4. **Project# 1009289**
13DRB-70418 MINOR - PRELIMINARY/FINAL PLAT APPROVAL
- MORRIS SURVEYING agent(s) for GRAND CENTRAL DEVELOPMENT request(s) the above action(s) for all or a portion of Lot(s) A-1, Block(s) 11, **LA MESA** zoned SU-2 MIXED USE, located on CENTRAL BETWEEN ALCAZAR AND SAN PABLO containing approximately .967 acre(s). (K-19) **THE PRELIMINARY/FINAL PLAT WAS APPROVED WITH FINAL SIGN OFF DELEGATED TO TRANSPORTATION FOR DEDICATION OF ADEQUATE RIGHT OF WAY OF CENTRAL AVENUE AT THE SATISFACTION OF TRANSPORTATION DEVELOPMENT AND TO PLANNING FOR CORRECTION TO NOTE 3 AND AGIS DXF.**

DRB CASE ACTION LOG - BLUE SHEET

Project #: 1009289 Application #: 13DRB-704108
Project Name: La Mesa
Agent: Morris Surveying Phone #:

Your request was approved on 1-30-13 by the DRB with delegation of signature(s) to the following departments - outstanding comments to be addressed

GENERAL NOTES, APPROVALS, CERT. SHEET 1 OF 3

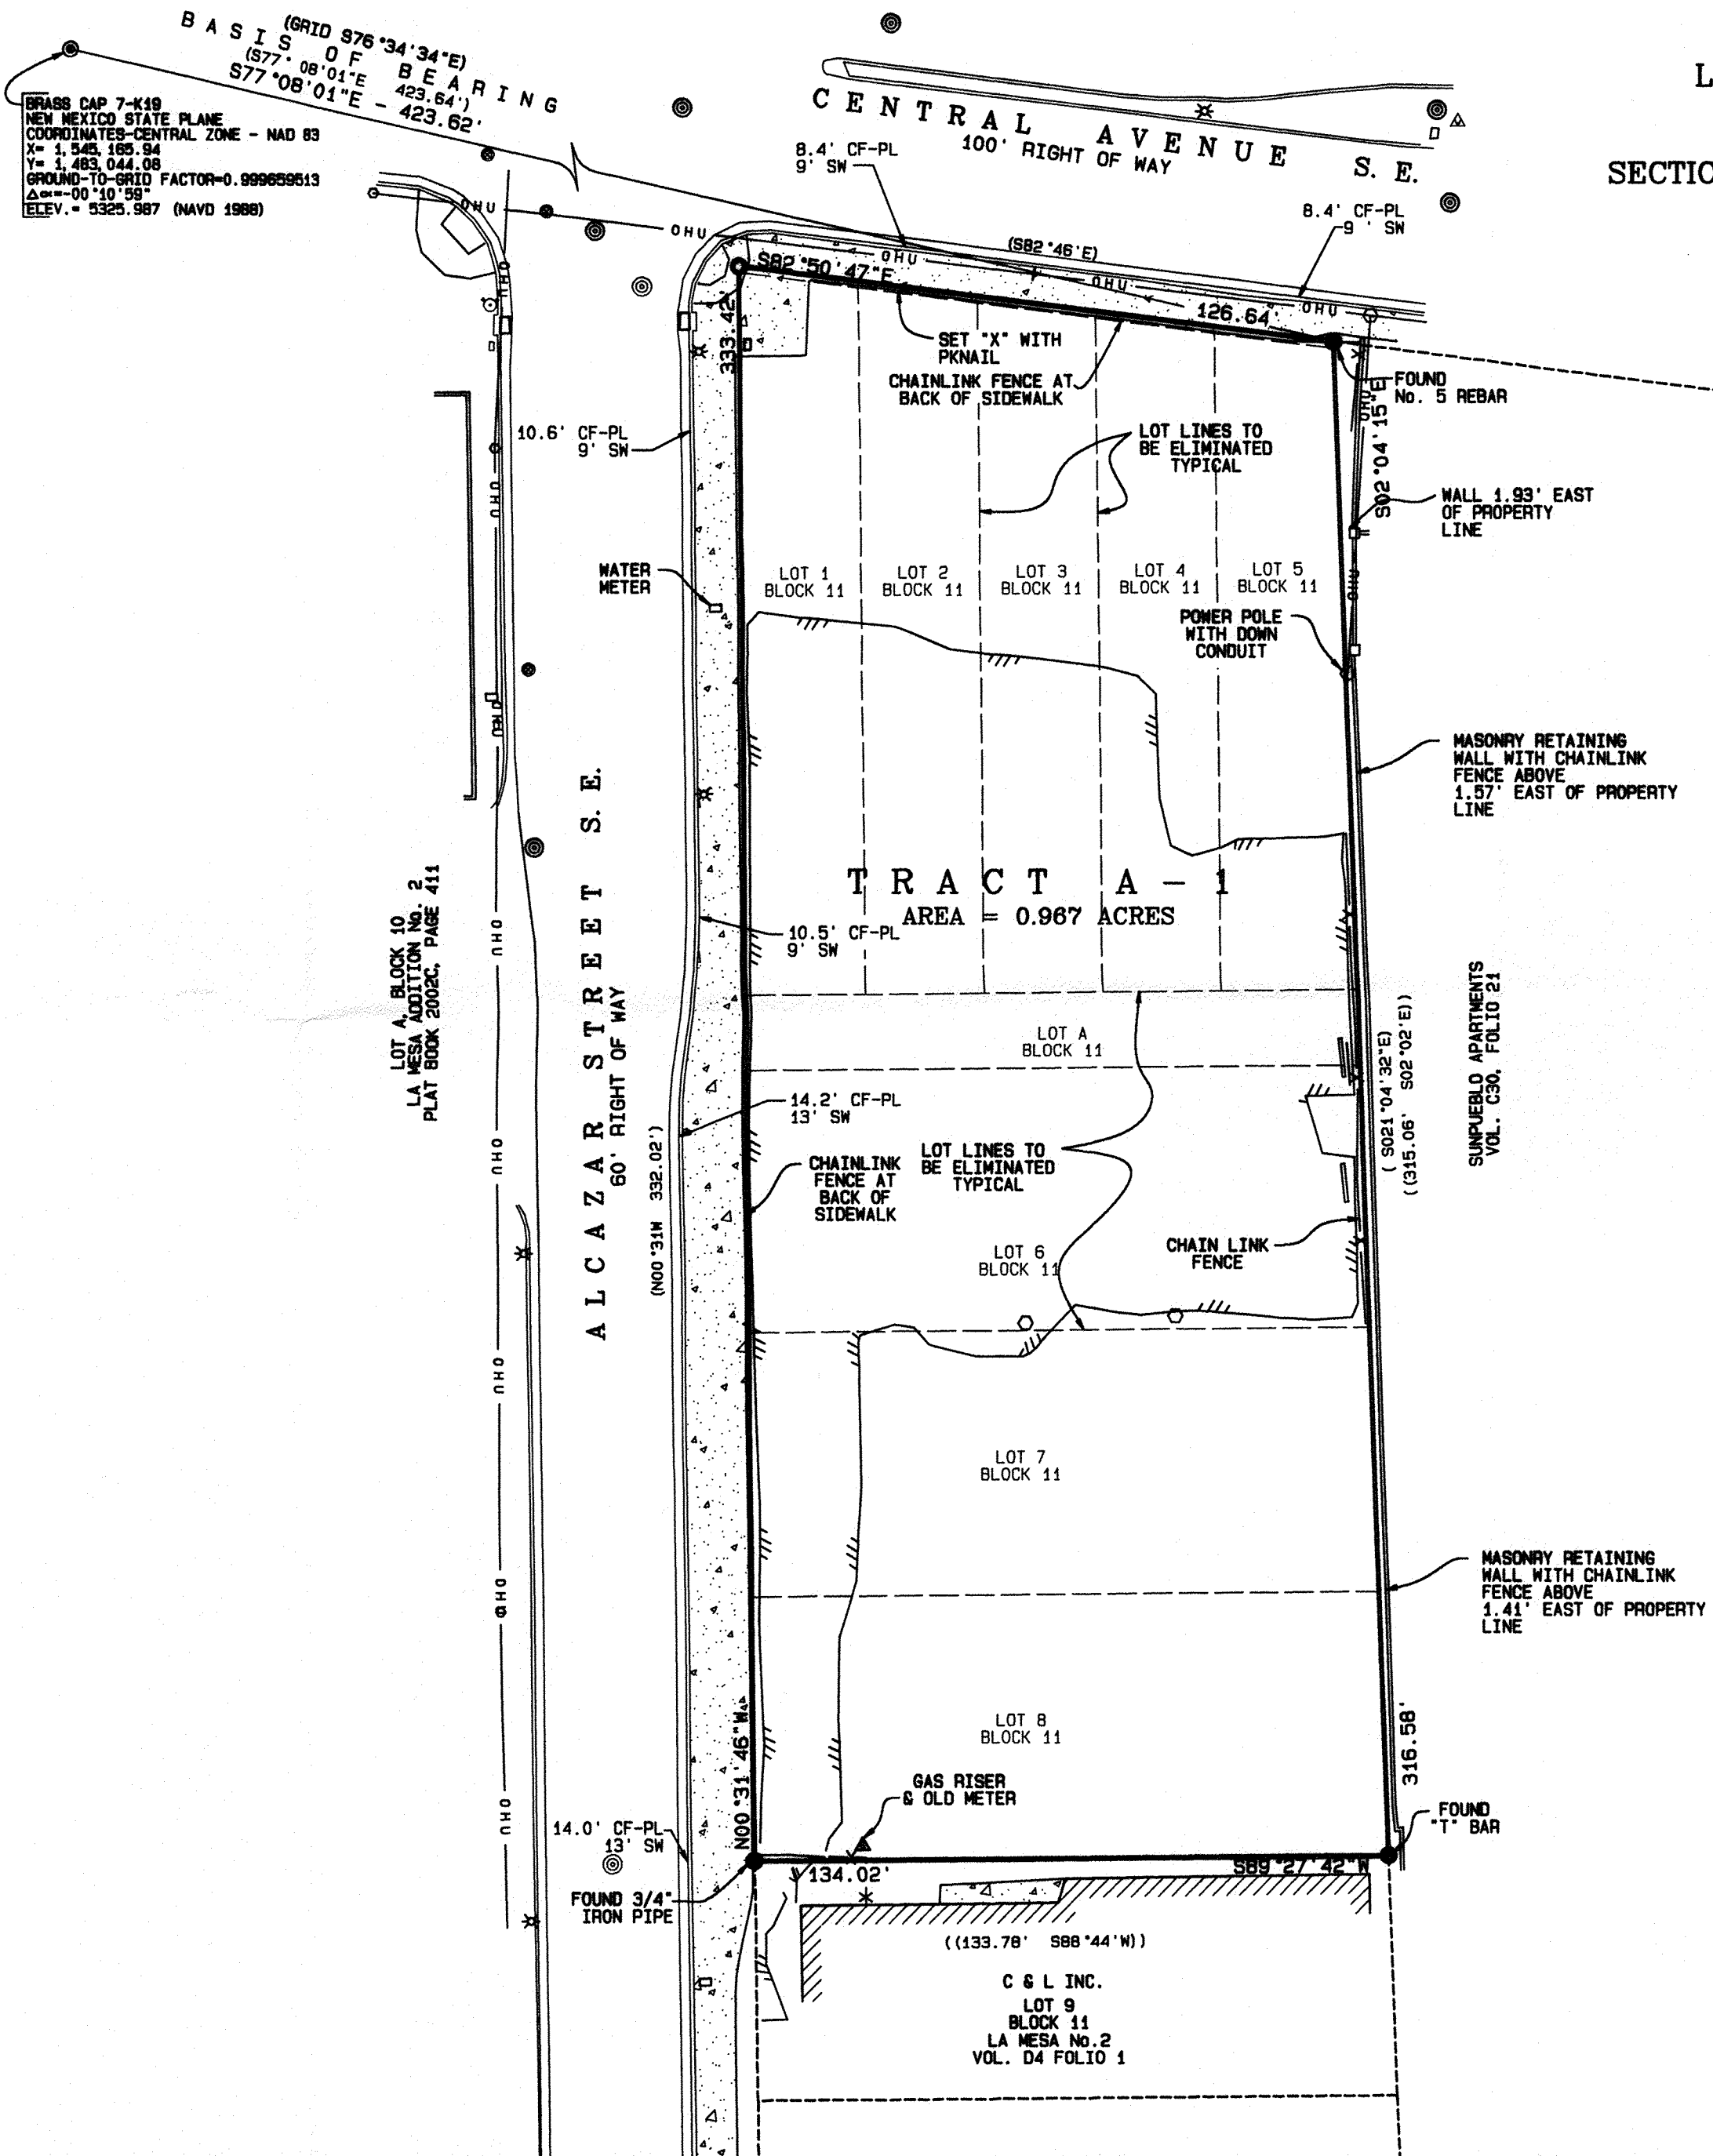
PLANNING (Last to sign): revise Note 3, dat
